STATE OF NORTH CAROLINA
DEPARTMENT OF TRANSPORTATION

Addendum No. 1

Cleveland County (R-2707F)

US-74 (Shelby Bypass) From East Of SR-1162 (Peachtree Road)

PROJECT REFERENCE NO. R-2707F	SHEET NO. 5
ROADWAY DESIGN ENGINEER	HYDRAULICS ENGINEER
<p>DOCUMENT NOT CONSIDERED FINAL UNLESS ALL SIGNATURES COMPLETED</p>

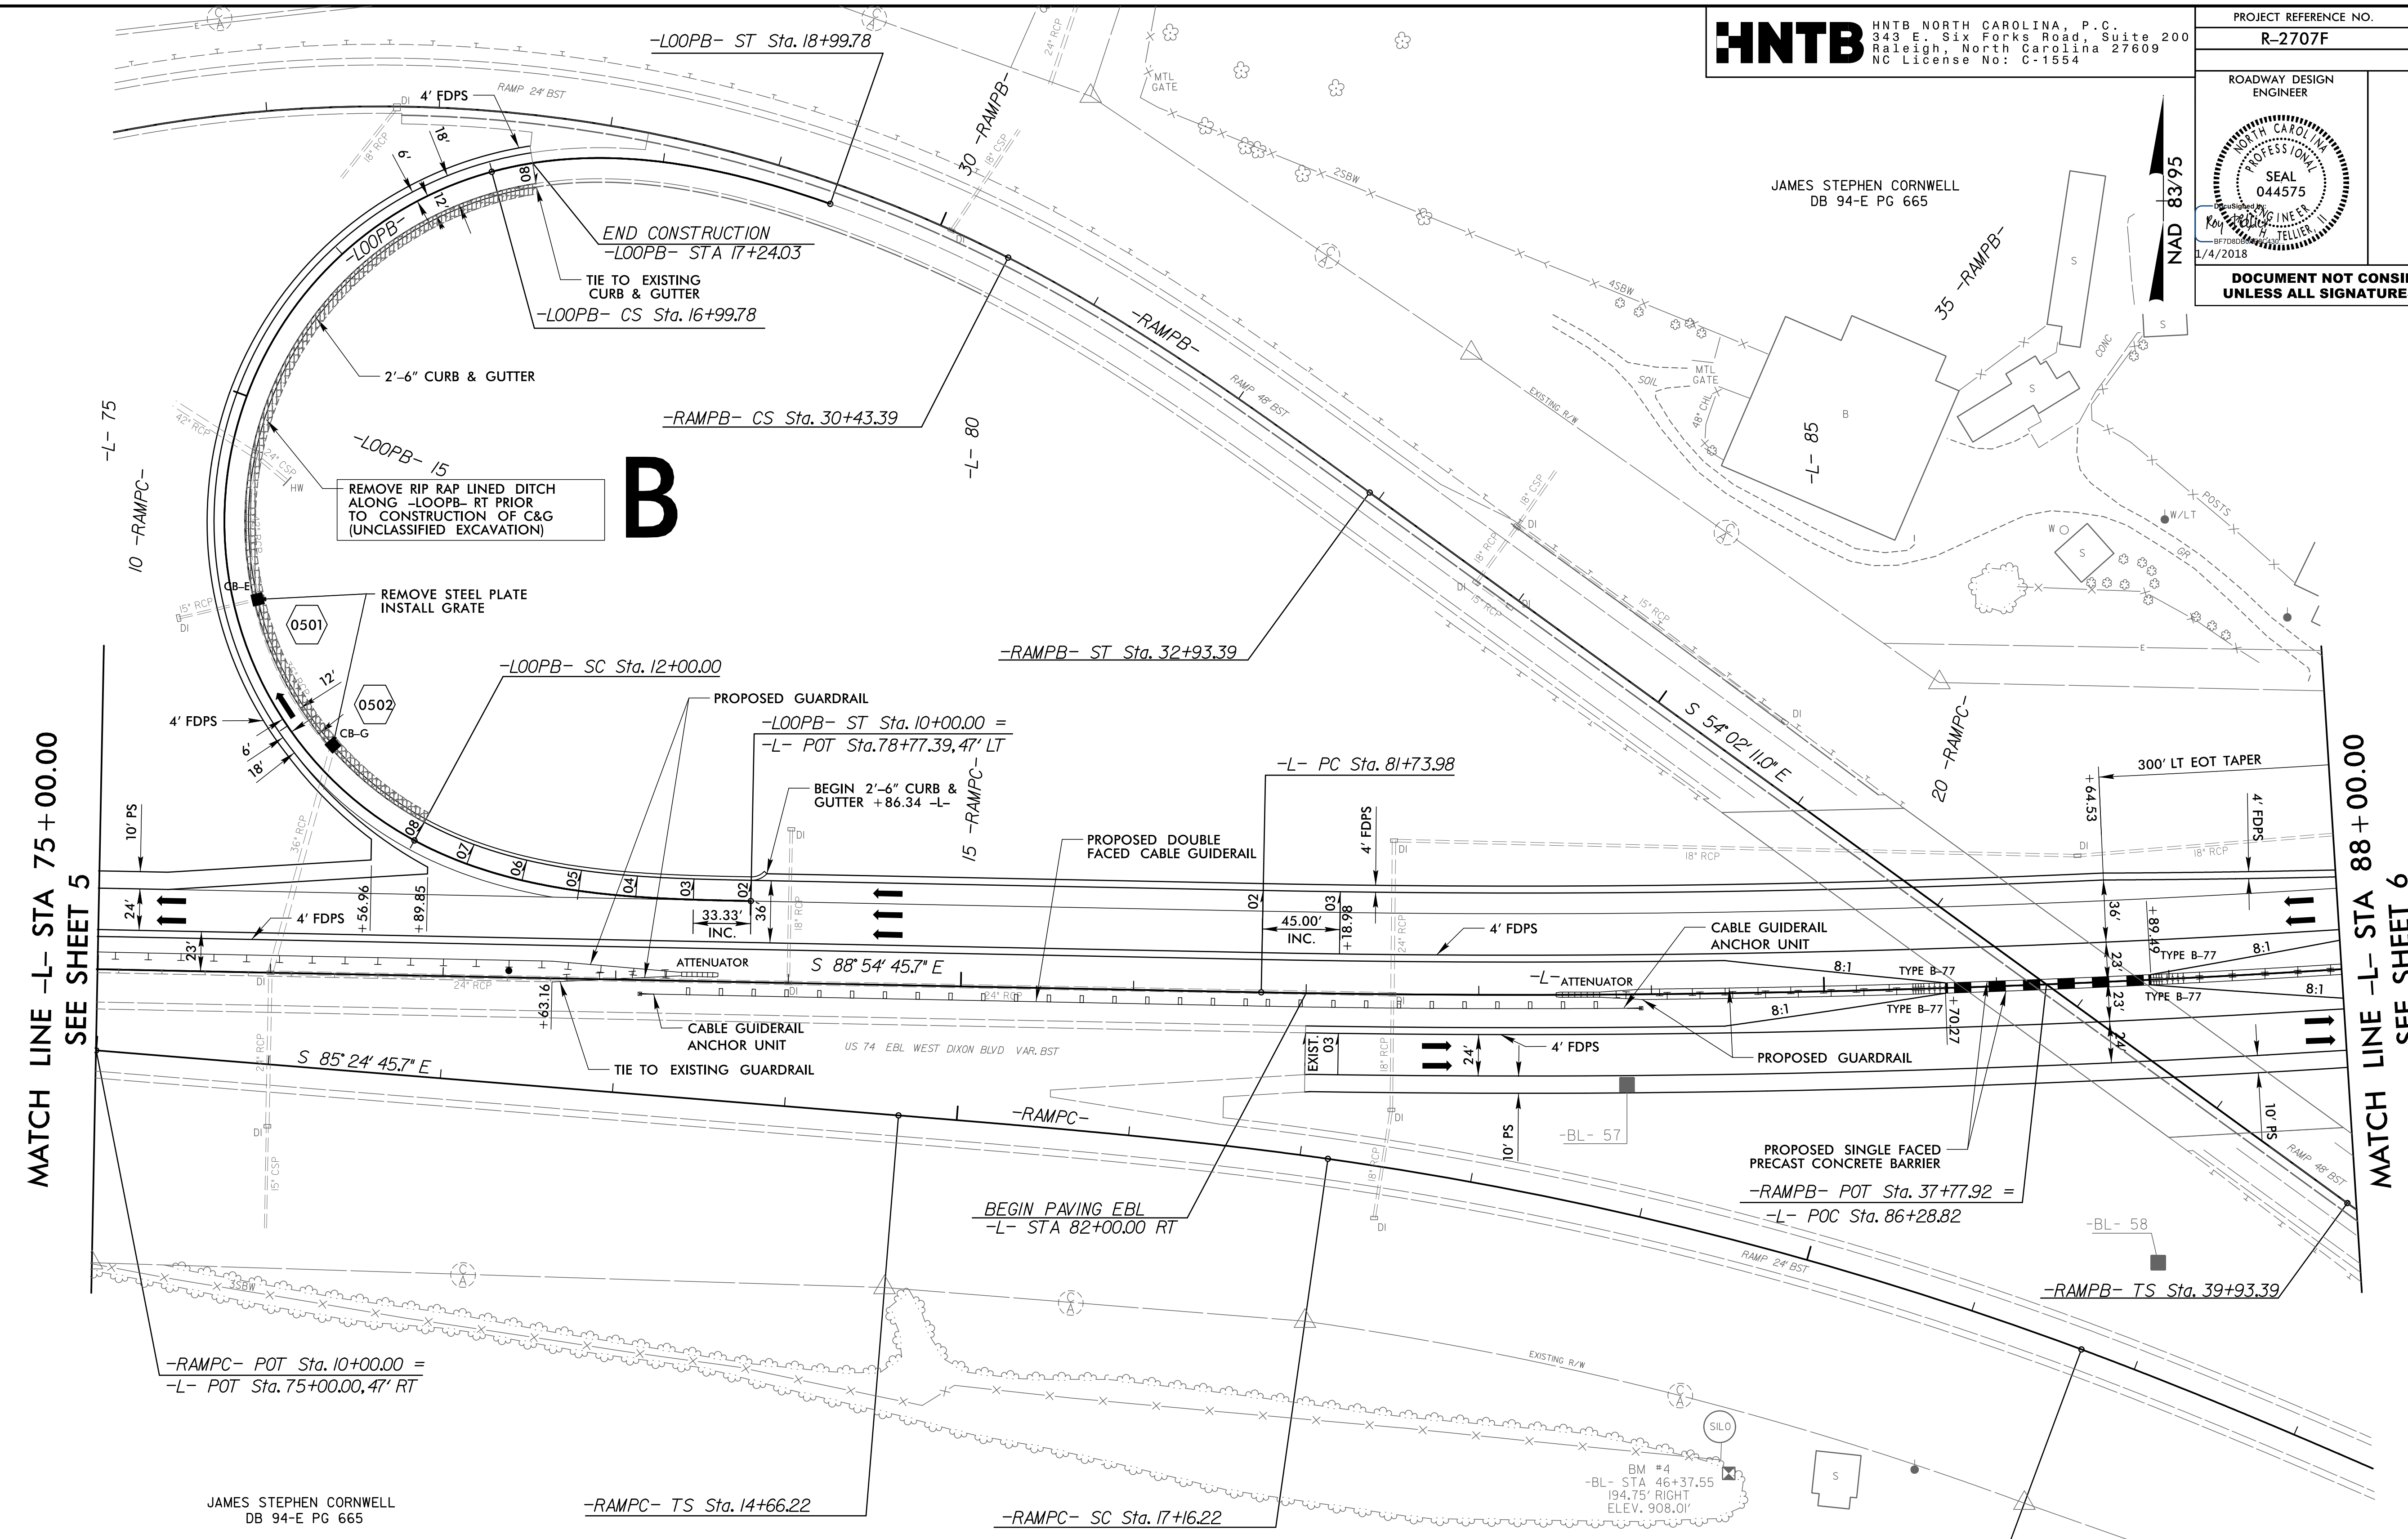
Sheet No.	Revisions
1A	Revised the Index Of Sheets to show that Sheet 3B-2 no longer contains an Earthwork Summary
3B-2	Revised to remove the Earthwork Summary
5	Revised the note concerning the removal of the rip rap lined ditch in Loop B. This will be paid as Unclassified Excavation
